Planning - Case Comments

Project Number: PR-2024-011242

Application Number: SI-2025-00079

Project Name: 1401 Innovation Parkway SE- PNM (ESS)

IRRIGATION LAYOUT

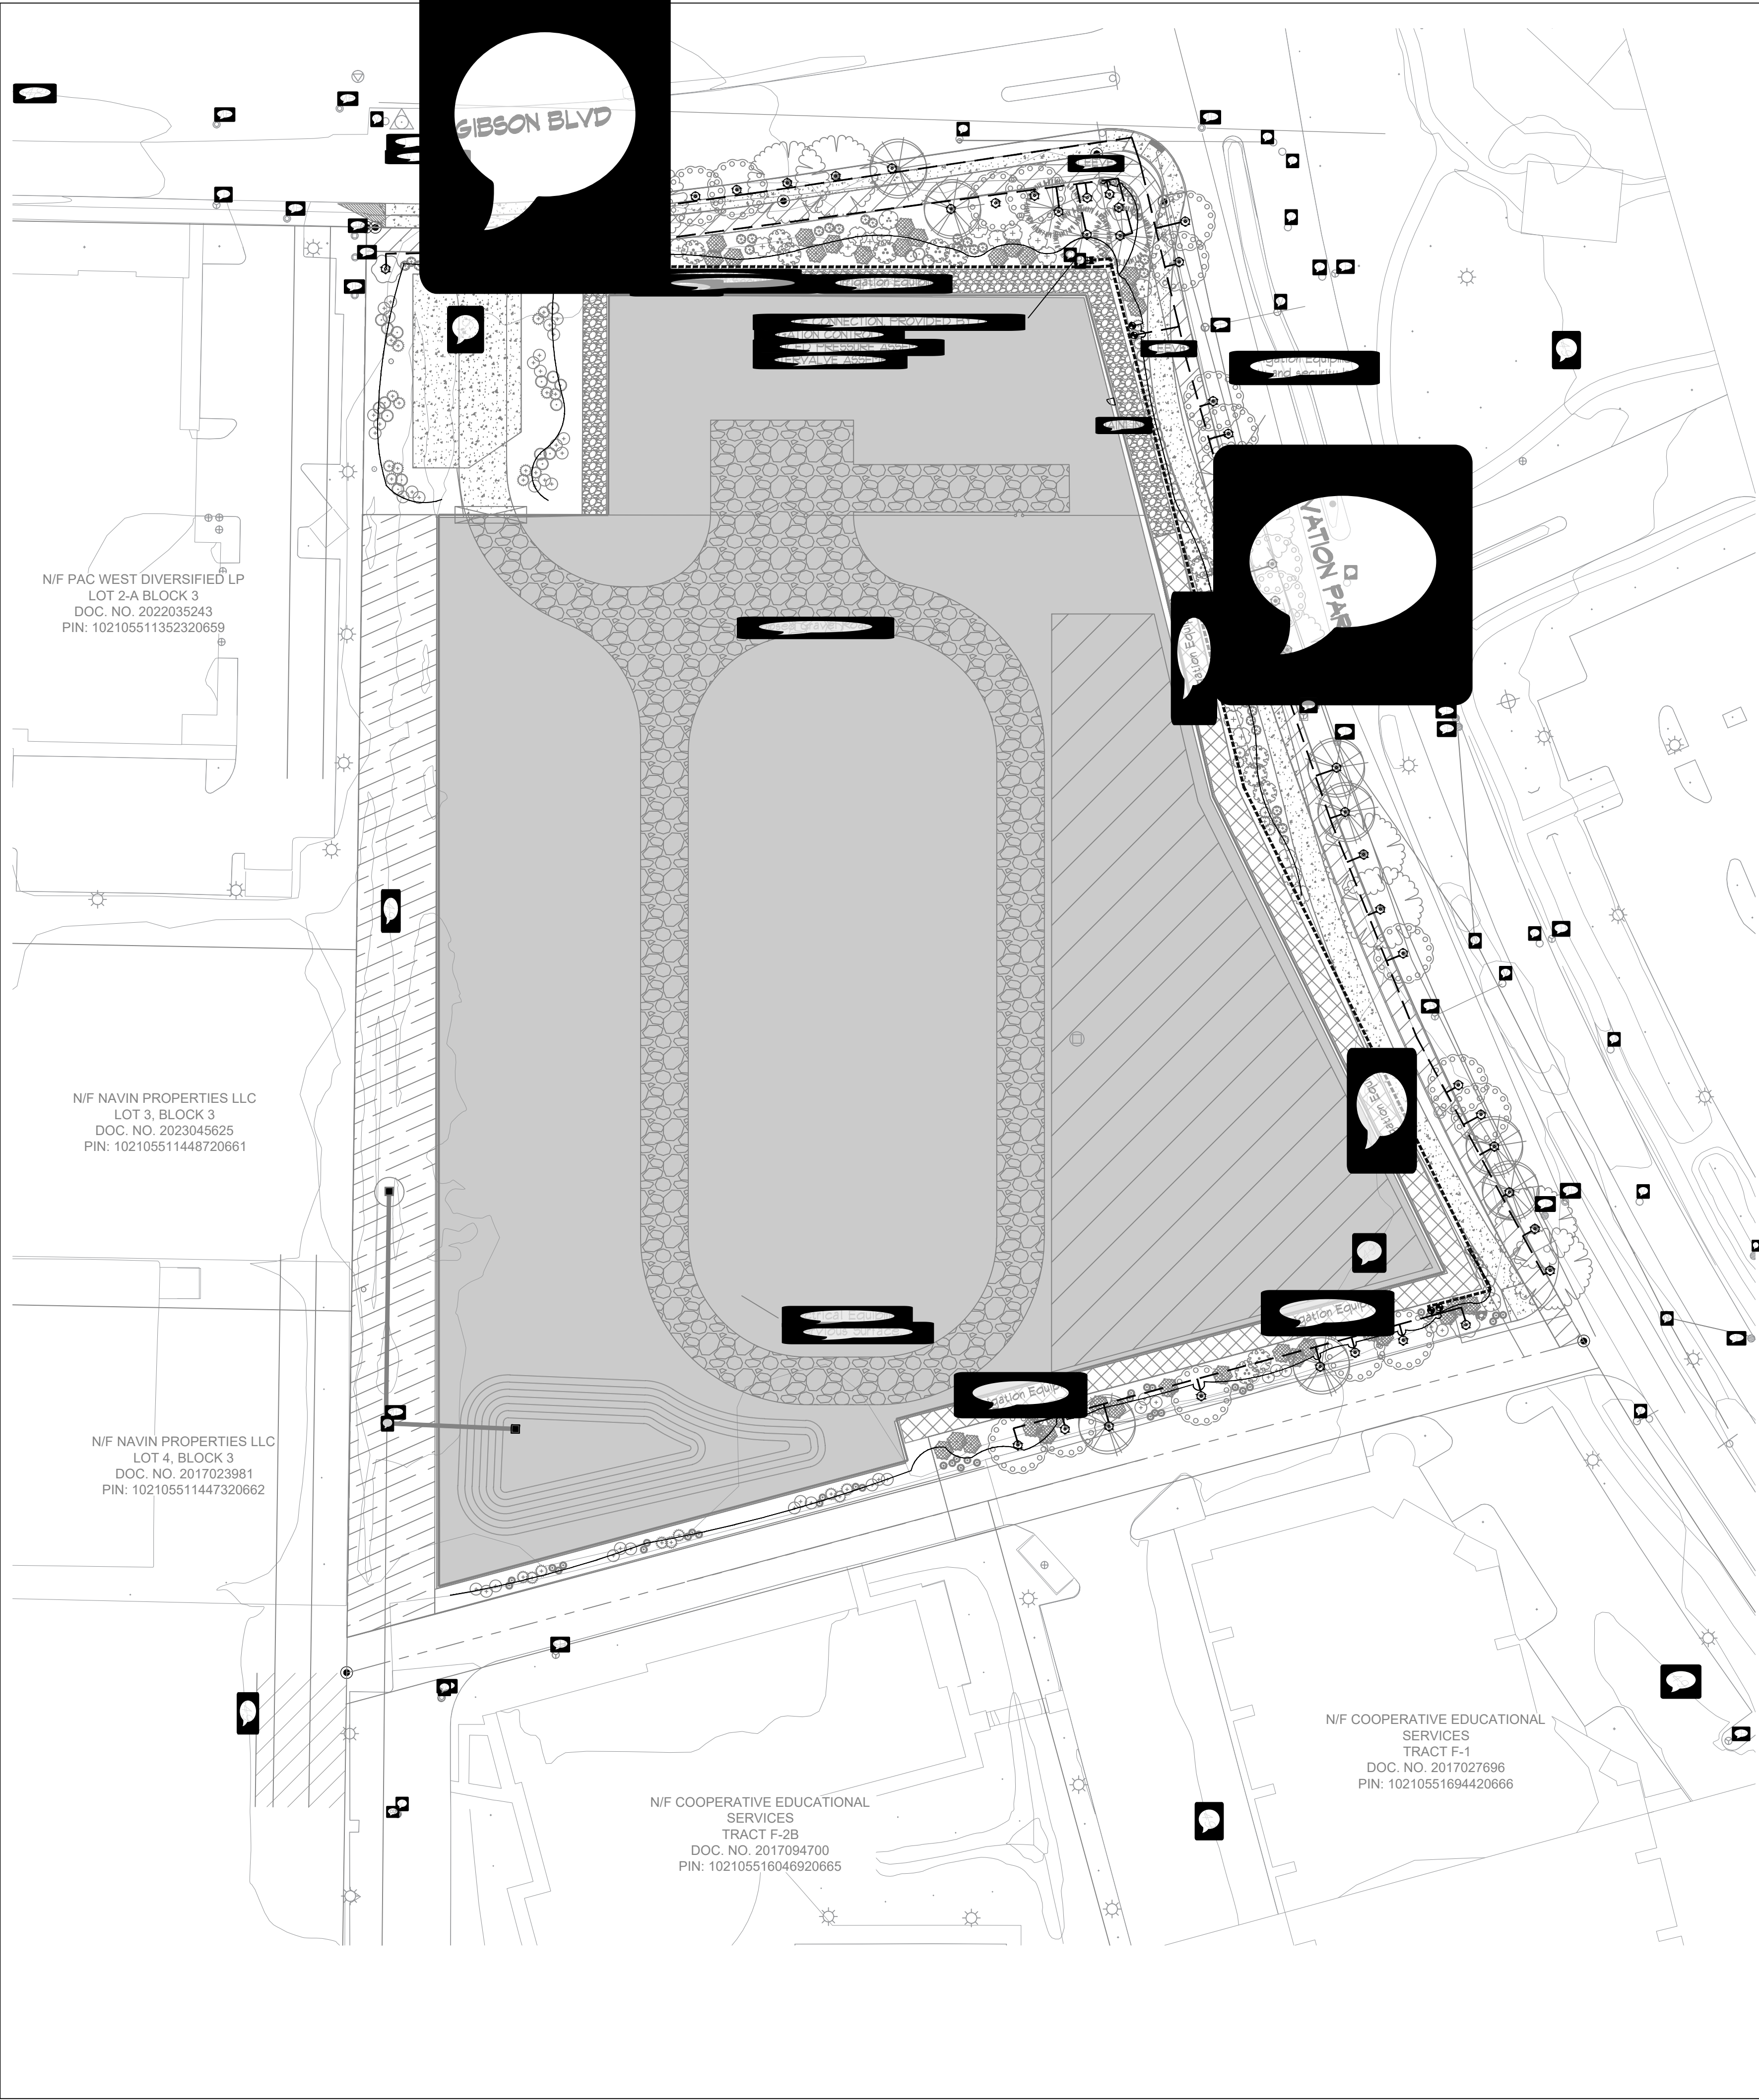
- Per 5-6(C)(14)(a), irrigation systems shall comply with Section 8 of the ABCWUA Legislation and Ordinances (Cross Connection Prevention and Control Ordinance).
- Per 5-6(C)(14)(b), all irrigation systems shall be designed to minimize the use of water.
- 5-6(C)(14)(c), all non-residential landscape irrigation shall have automatic timers and/or programmable settings to avoid overwatering. Confirm compliance as this site will also be 'unmanned'.

▪ **PNM RESPONSE: Confirmed, all irrigation is on programable schedules/timers. This detail can be reviewed on the updated 2 Landscaping plan.pdf pages 3 and 4.**

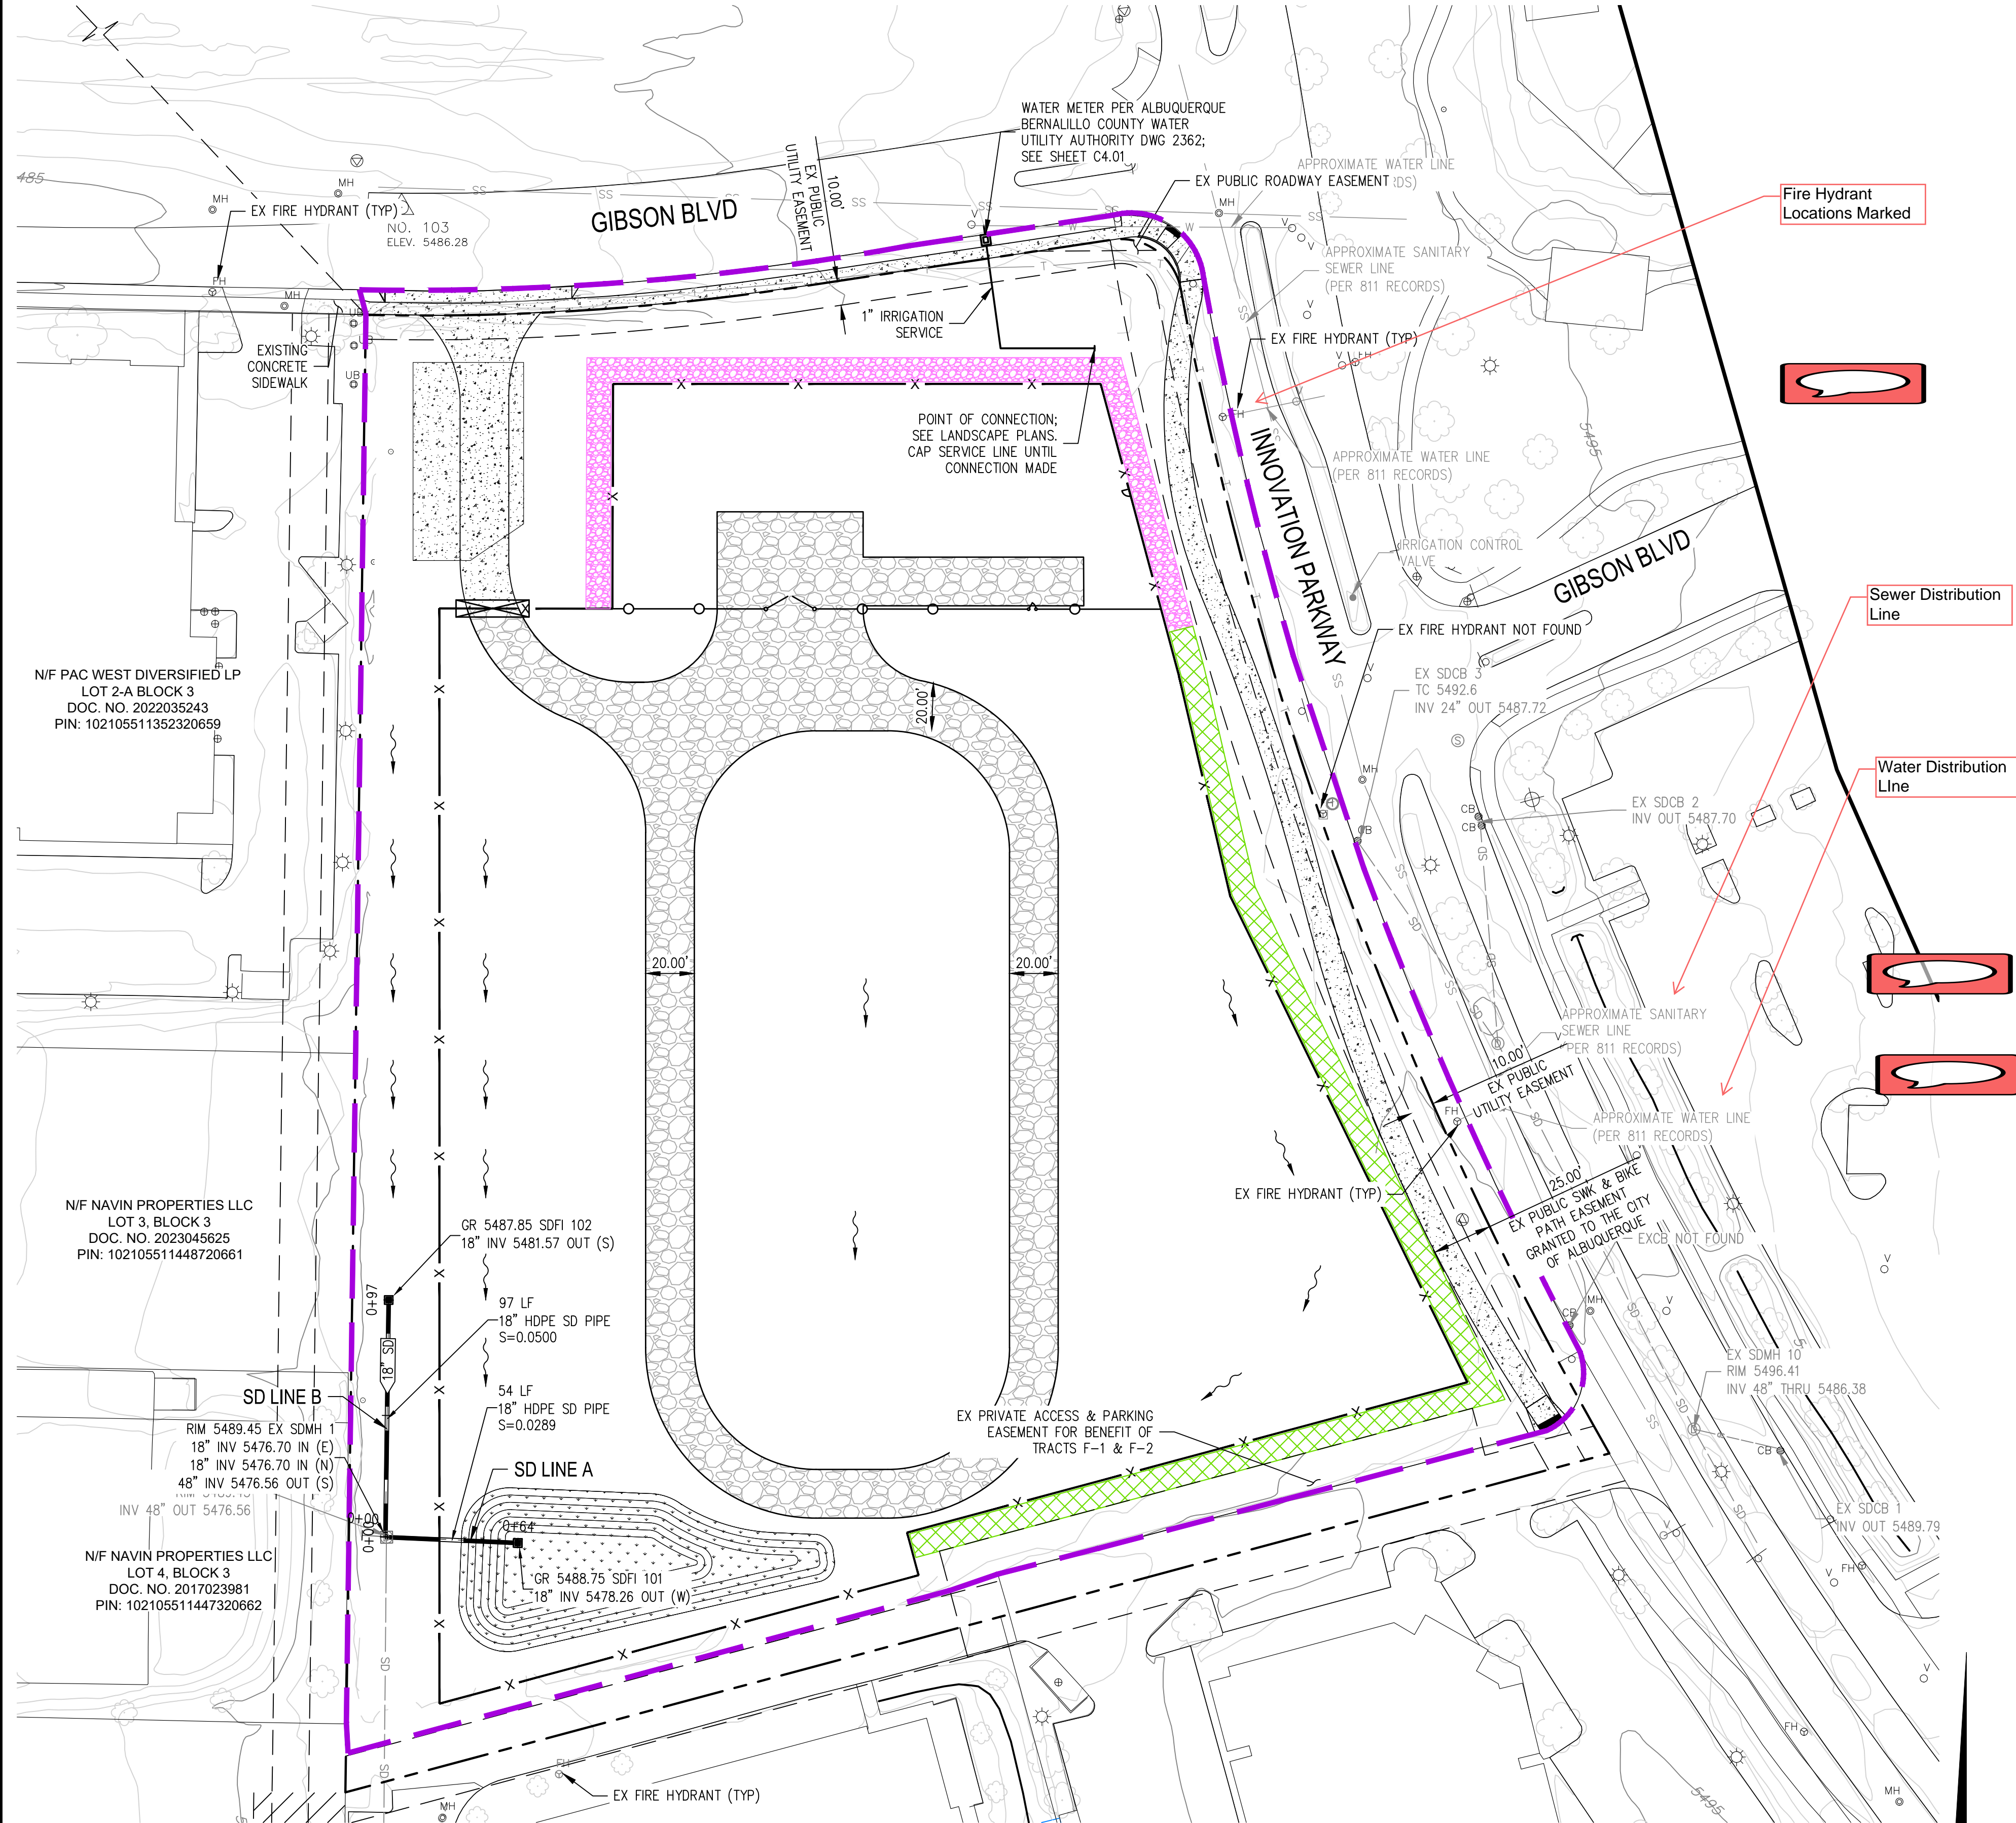
- A Sensitive Lands Analysis was submitted with the application. No arroyos or drainage facilities are located on the site.
- **A note needs to be added to the plan: “Pond stabilization per Standard Specification 1013.”** [Drainage Ponds Slope Stabilization and Seeding Requirements.pdf \(cabq.gov\)](#)
Confirm compliance with Section 1013.

- Please also add a note: in regard to seed/native plant to be used in the slope stabilization of the drainage pond.

▪ **PNM RESPONSE: The will be pond is designed to meet the Standard Specification 1013.** This notation can be found in #3 Grading and Drainage.pdf file pg3 DWG: C5 Stormwater Control Plan under “Typical Basin Section”.

- **PNM RESPONSE: This notation can be found in #3 Grading and Drainage.pdf file pg3 DWG: C5 Stormwater Control Plan under "Typical Basin Section".**
